REQUEST

Current Zoning: N1-B (neighborhood 1-B)
Proposed Zoning: INST(CD) (institutional, conditional)

The petition proposes to develop a 15,000 square foot facility for special needs youth and adults on vacant land.

PLANNING STAFF REVIEW

RZ-2.0

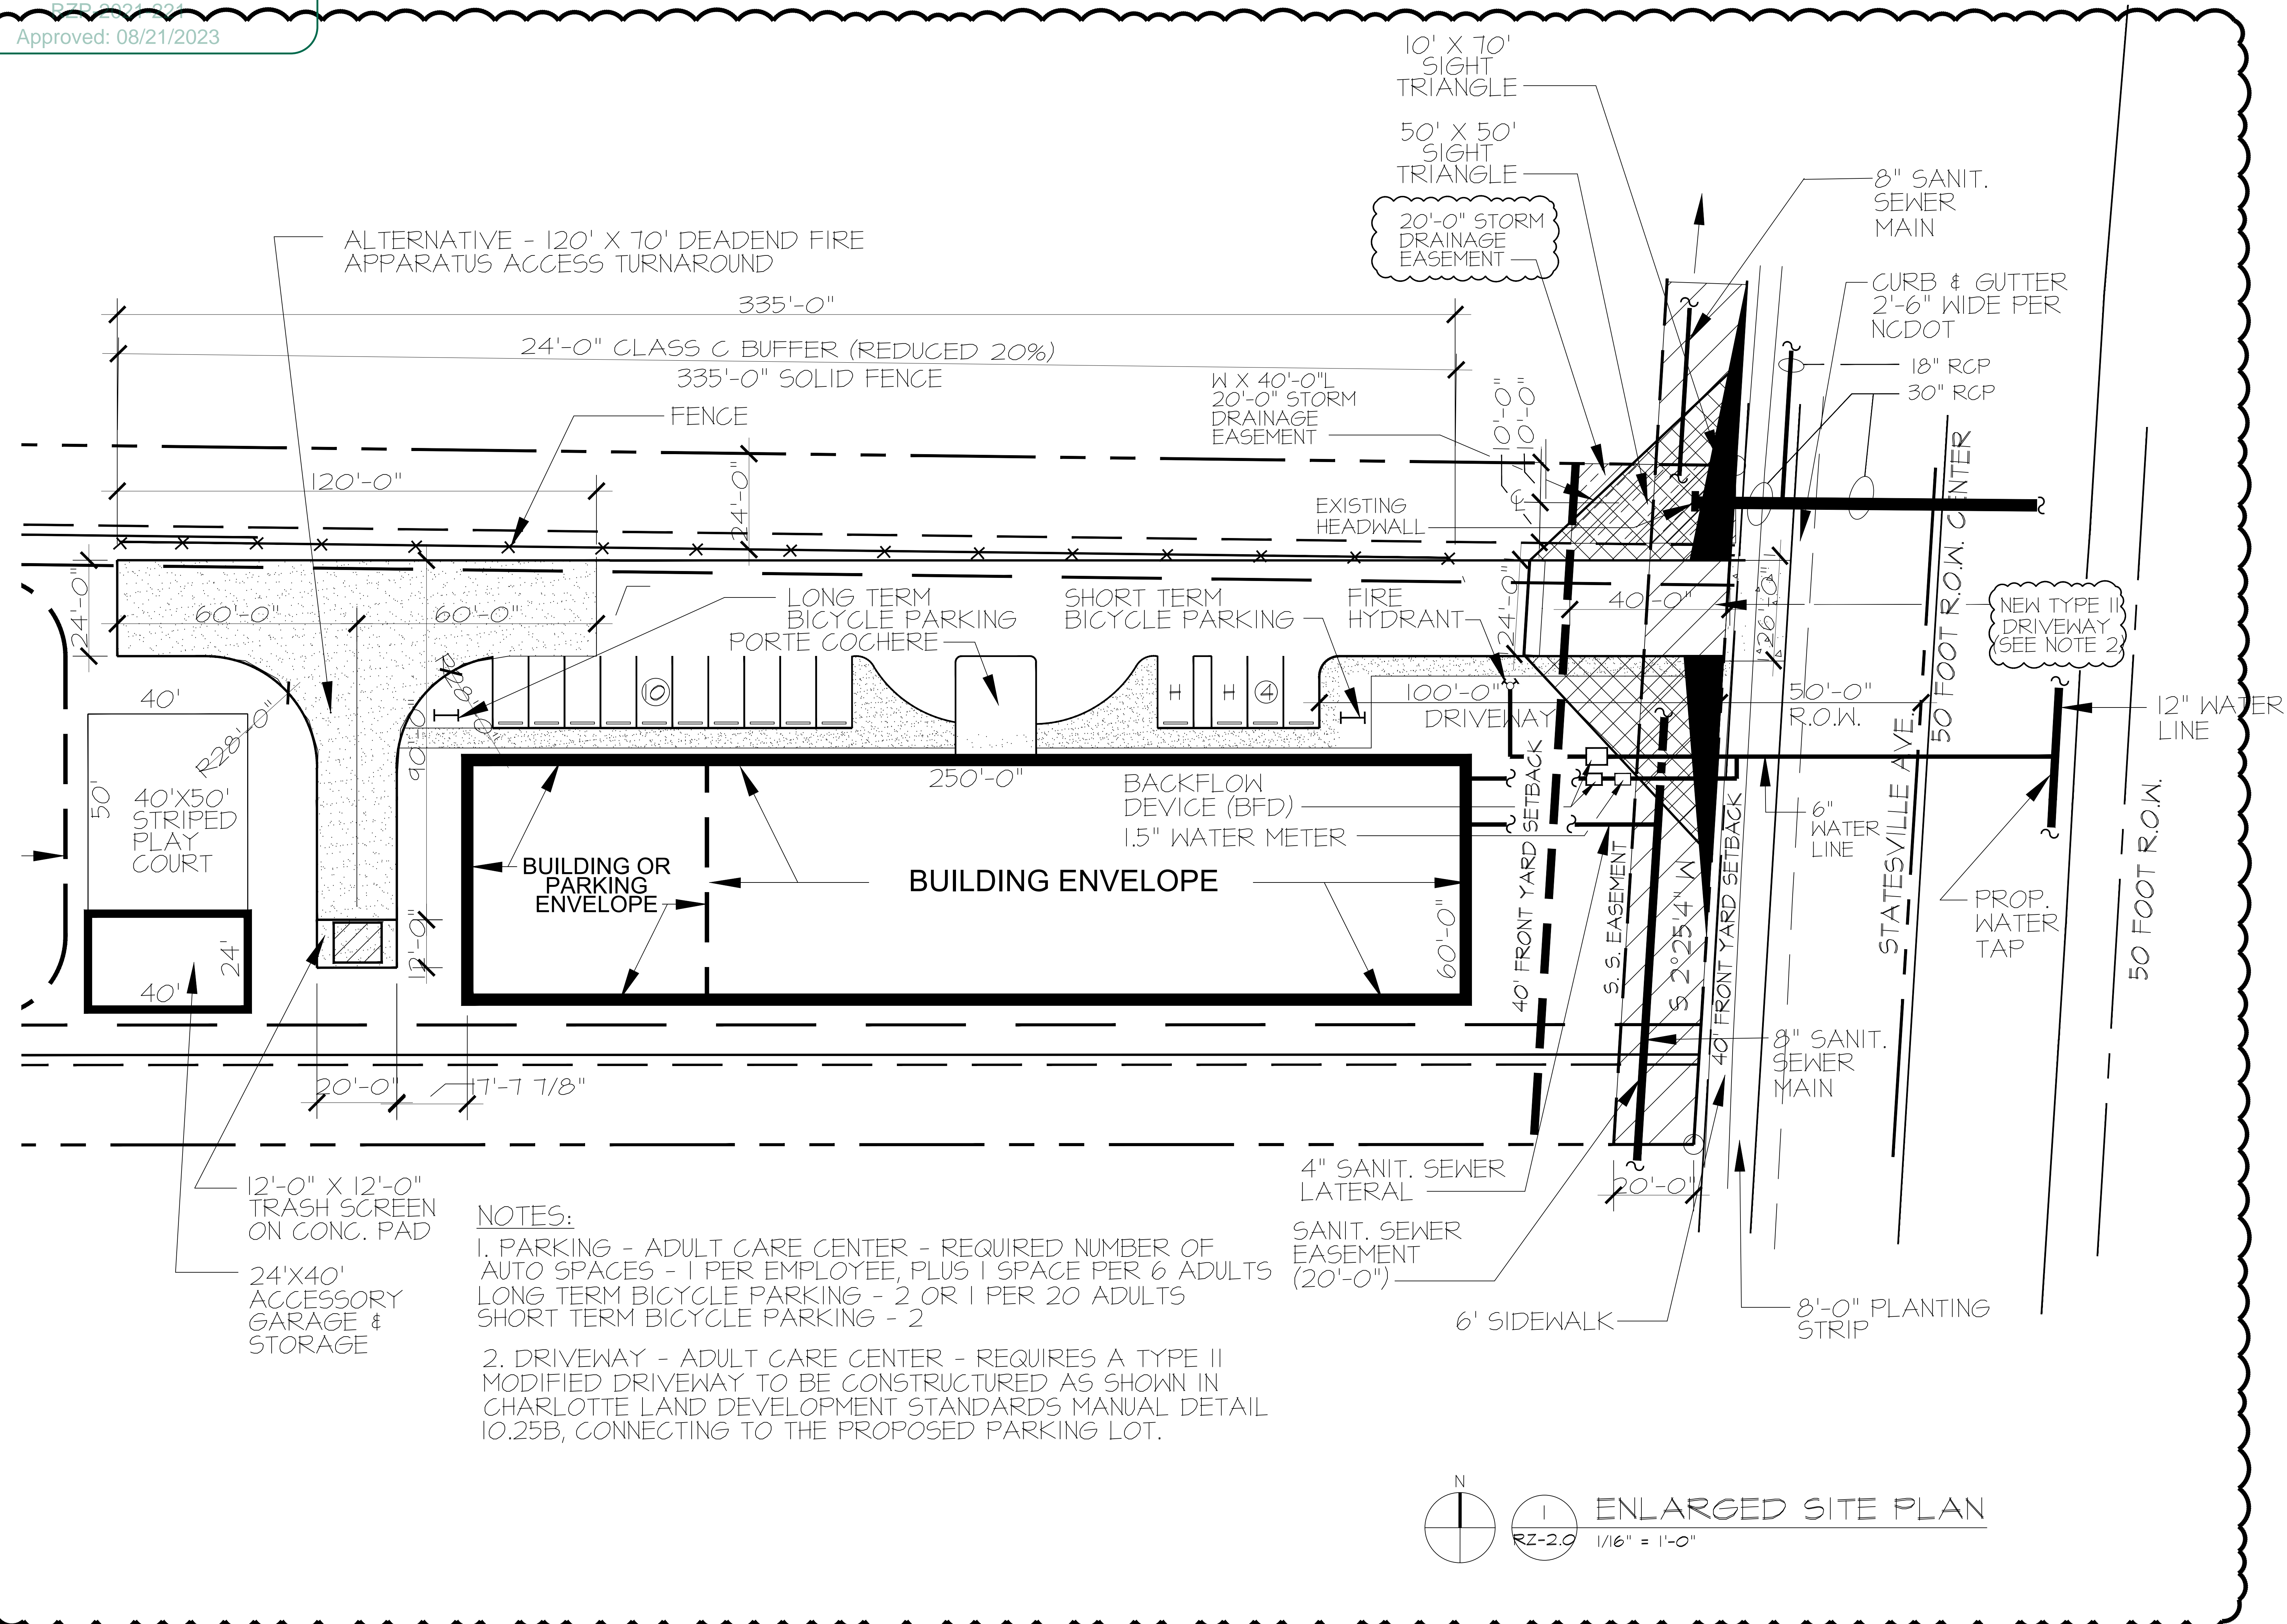
1. ~~Revise site plan and conditional note(s) to commit to construct a Type II Modified driveway as depicted in Charlotte Land Development Standards Manual detail 10-25E connecting to the proposed parking lot.~~ Addressed
